Project Name:	170 Anderson Street	Project ID:	2014-075
Address:	170 Anderson Street	CBL:	010 E002
Applicant:	Sherwood Hamill		
Planner:	Barbara Barhydt, Development Review Services Manager

On July 18, 2014, the Planning Authority approved with conditions a Level II site plan for the building ramps and site work for at 170 Anderson Street. The decision is based upon the application, documents and plans as submitted for the application and prepared by Ryan Senatore. The proposal was reviewed for conformance with the standards of Portland's site plan ordinance.

To: Barbara Barhydt
From: David Margolis-Pineo
Subject: Public Services Review Comments
Re: 170 Anderson Street

SHEET TITLE:
SITE PLAN
LAYOUT

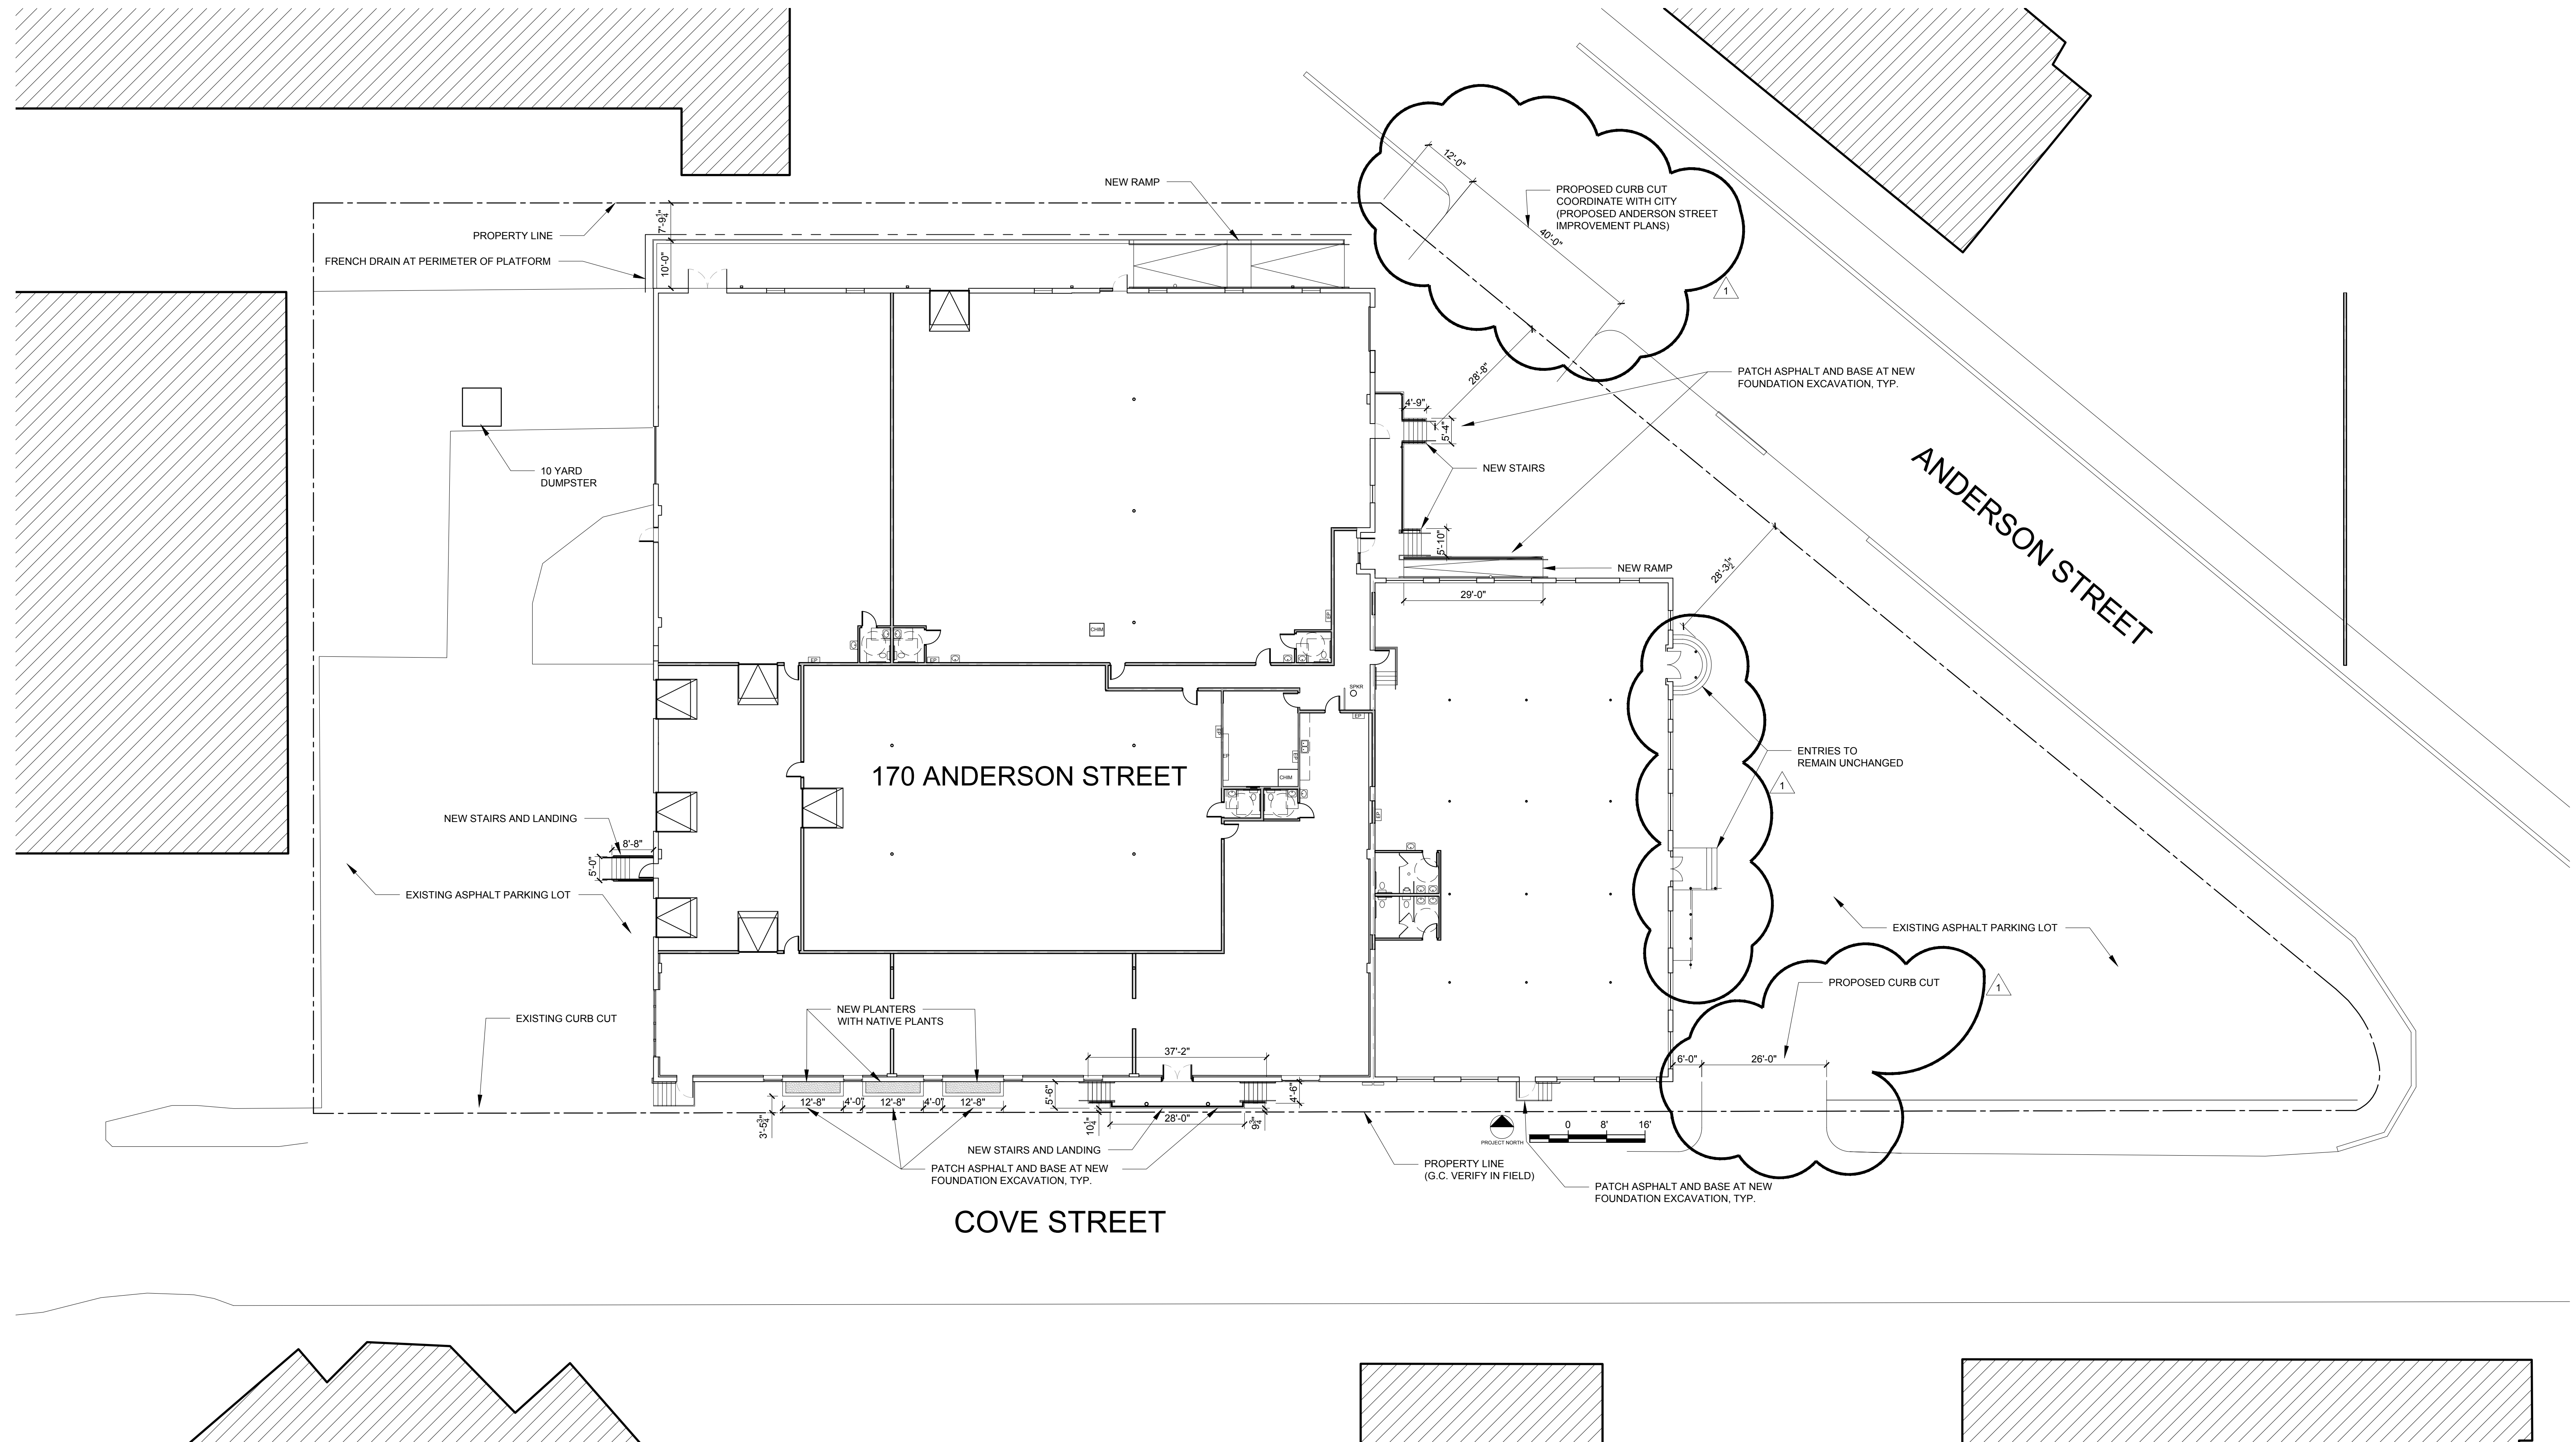
1. The Planning Authority with the support of the Department of Public Services waives the Technical Standard, Section 1.8 Sidewalks and Driveway Aprons for the frontage along Cove Street due to the narrow width of the right-of-way and the applicant's agreement to provide an alternative walking route with an easement for a trail connection to the Bayside Trail, subject to the following condition:
 - a. That the applicant shall submit an agreement or easement for the trail connection over the subject property be submitted for review, approval, and signing by the City prior to the issuance of a certificate of occupancy.

1. Prior to the curb cut modification proposed on Cove Street, a Street Opening Permit shall be required and a pre-construction meeting held to define the scope of work.
2. The applicant is allowed two drive cuts for this property. The maximum width allow for an industrial drive is 30'. When Anderson Street is reconstructed in the summer 2015, the City will work with the applicant to locate one 30' wide cut on Fox St. Until then no modifications to curb cuts on Fox St are required.
3. Applicant is requested to bicycle parking to accommodate two bikes.
4. The applicant shall submit an agreement or easement for the trail connection over the subject property be submitted for review, approval, and signing by the City prior to the issuance of a certificate of occupancy.

1. This Department is supportive of the sidewalk waiver request on Cove St.
2. Prior to the curb cut modification proposed on Cove Street, a Street Opening Permit shall be required and a pre-construction meeting held to define the scope of work.
3. The applicant is allowed two drive cuts for this property. The maximum width allow for an industrial drive is 30'. When Anderson Street is reconstructed in the summer 2015, the City will work with the applicant to locate one 30' wide cut on Fox St. Until then no modifications to curb cuts on Fox St are required.
4. Applicant is requested to bicycle parking to accommodate two bikes.
